Our Ref: SYD15/00301 (A10083768)
Your Ref: SSD 6954

**ENVIRONMENTAL IMPACT STATEMENTS (EIS) FOR IKEA MULTI-FUNCTION LOGISTIC
MARSDEN PARK, BLACKTOWN LGA (SSD 6954)**

ADJOINS DRAWING 802150511-01-1201

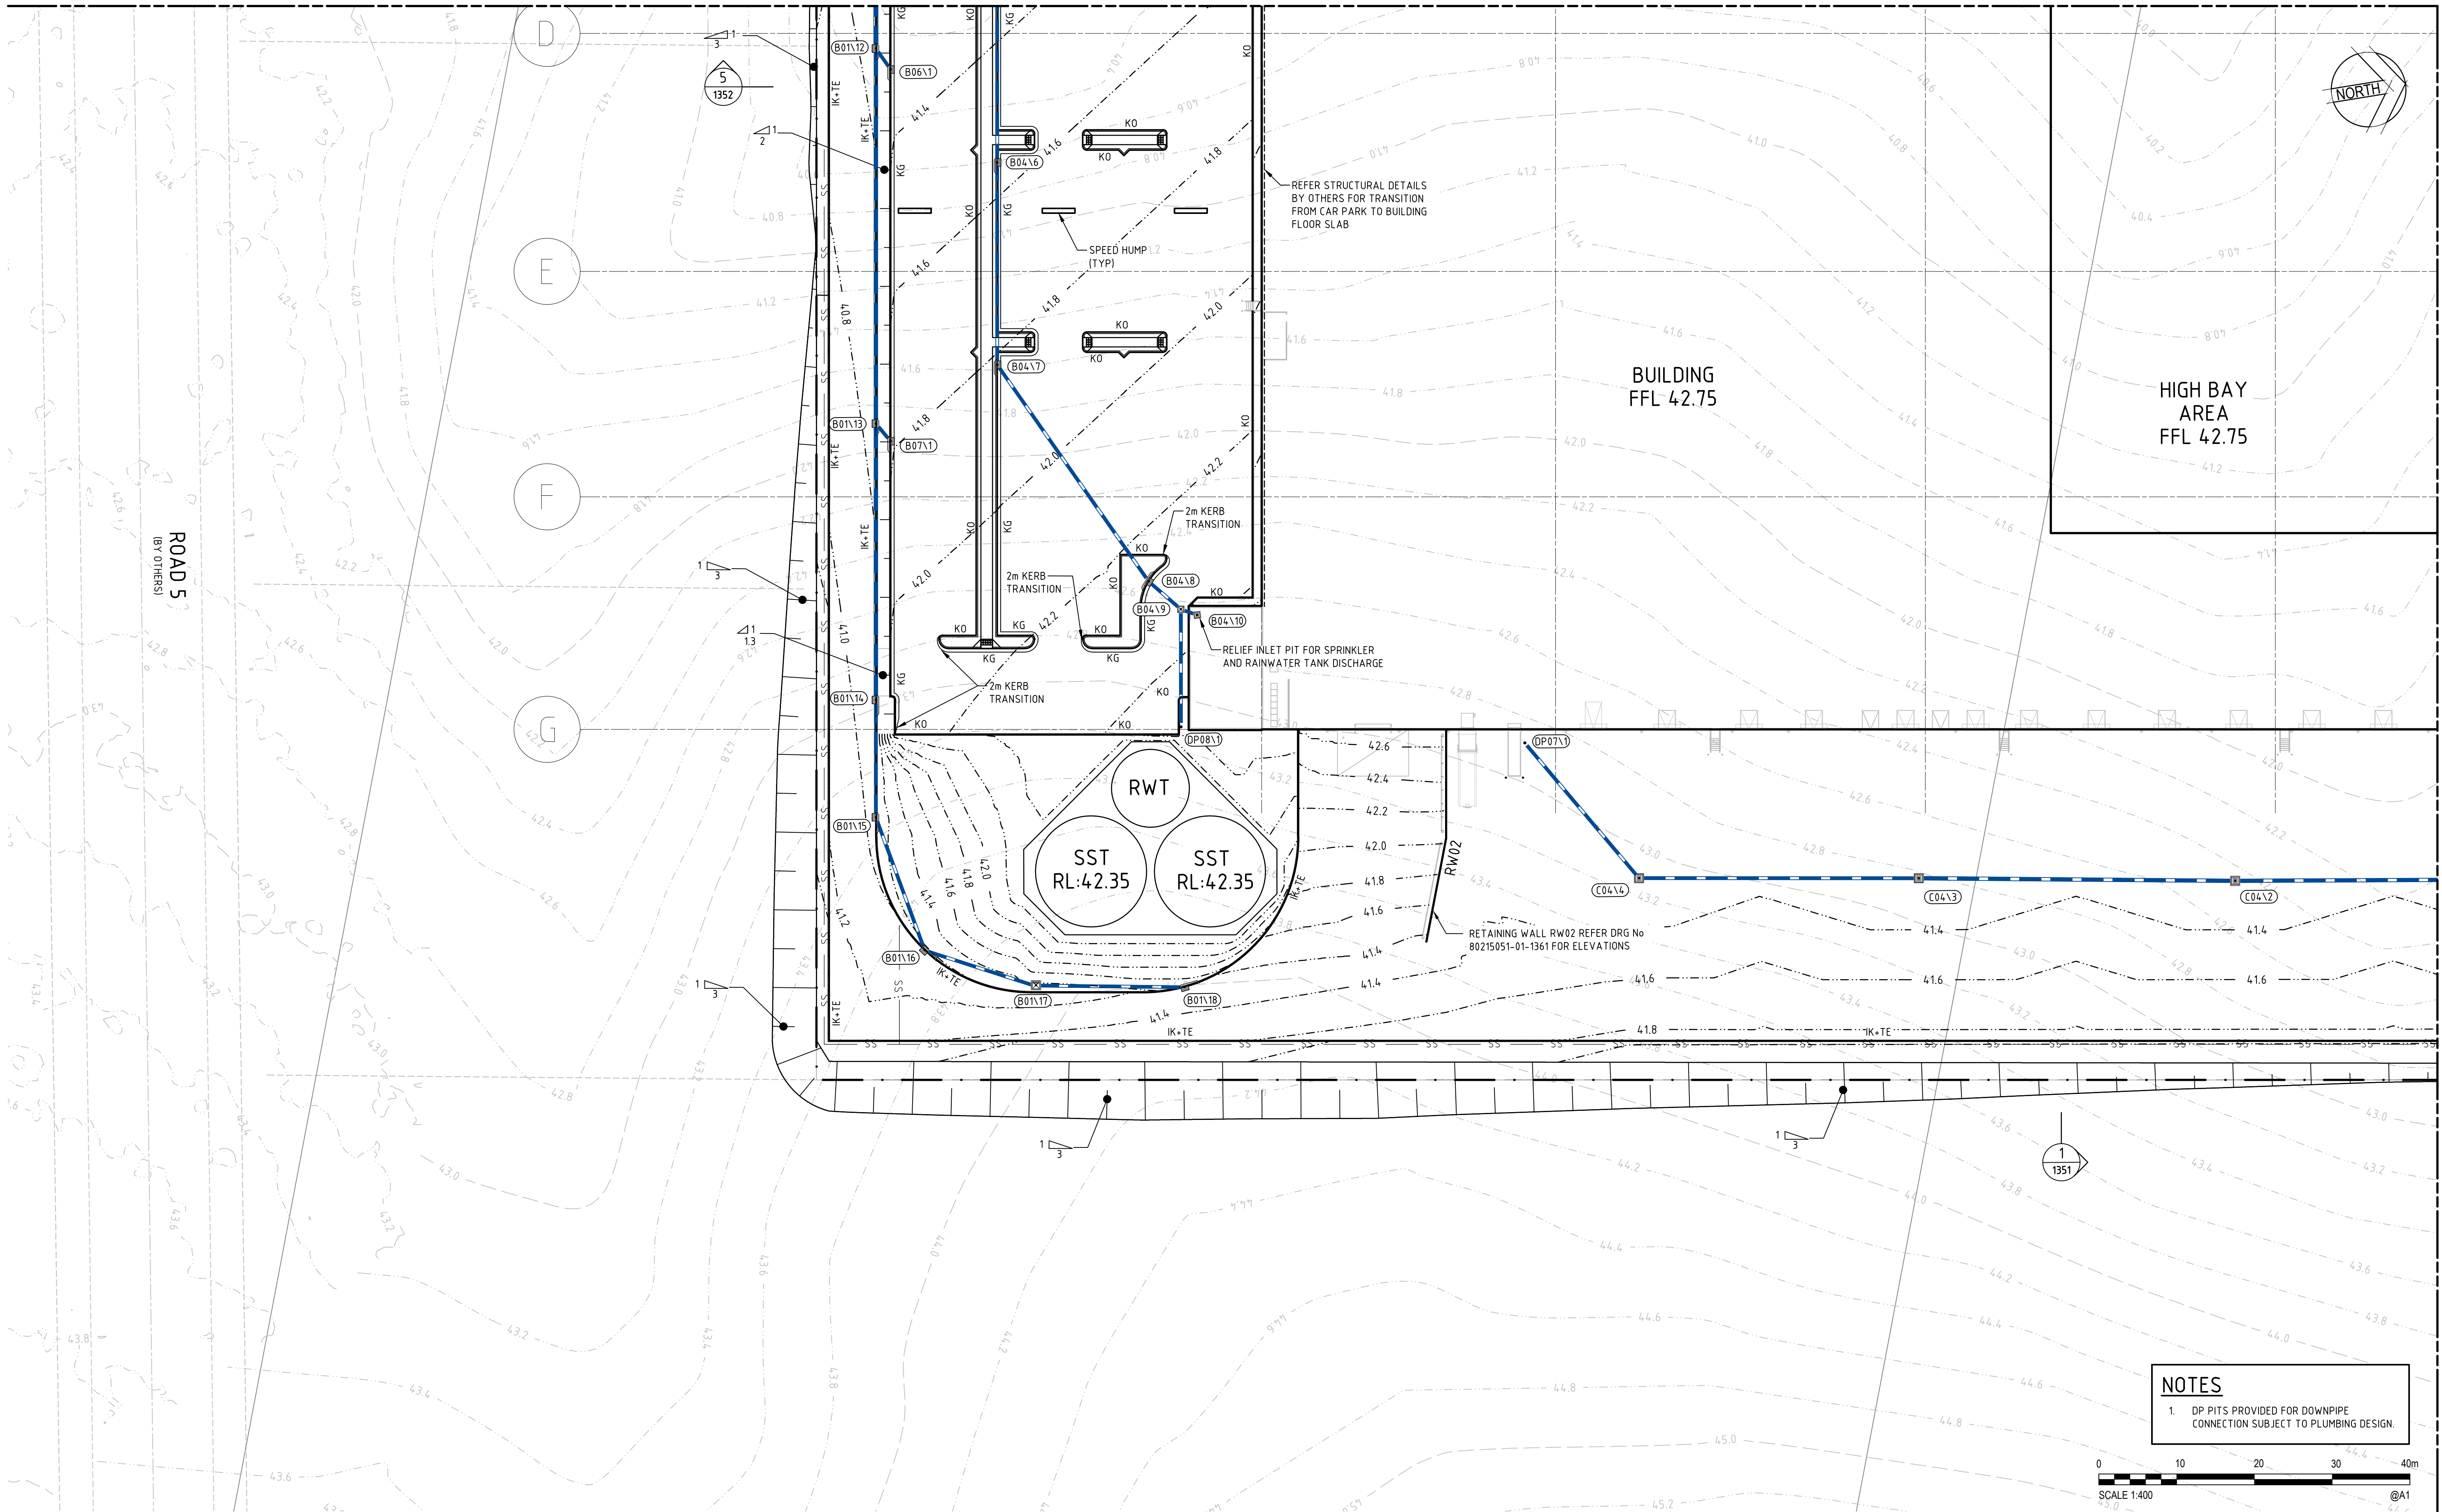
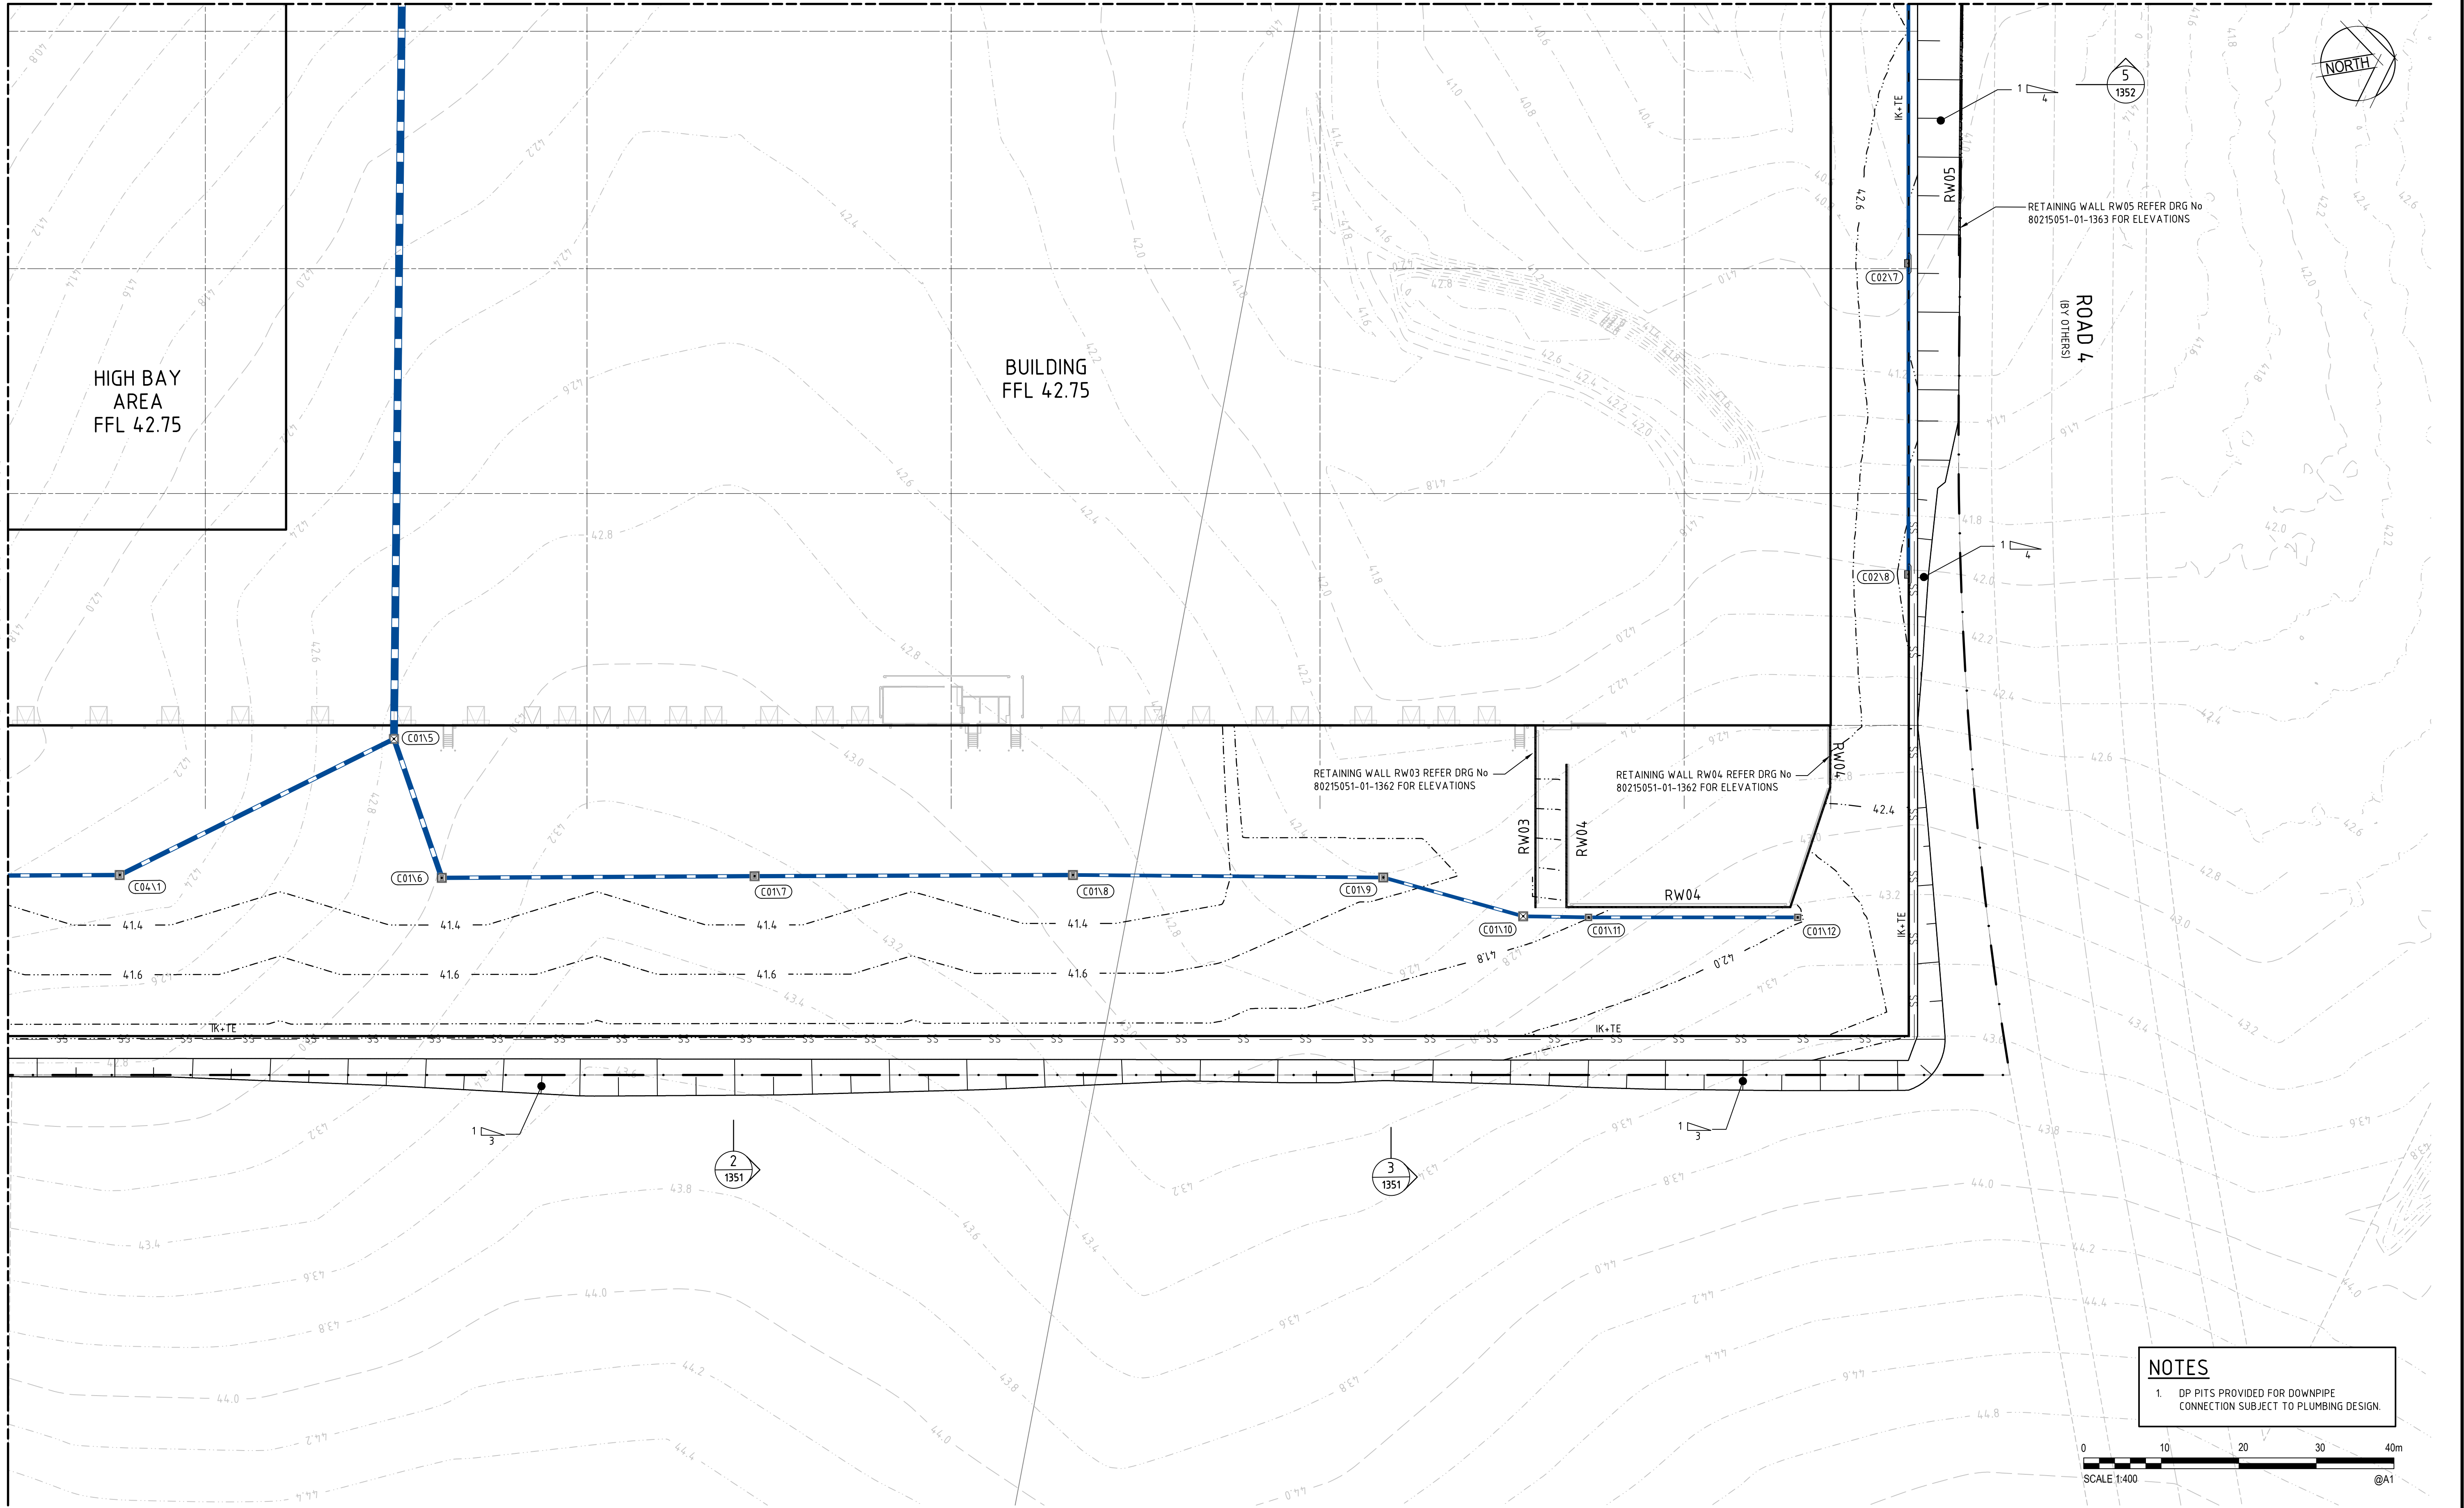
Roads and Maritime has reviewed the submitted application and raise no objection to the development proposal subject to the civil drawings being amended to reflect the updated access arrangements of all vehicles accessing the site from Richmond Road/Townson Road intersection.
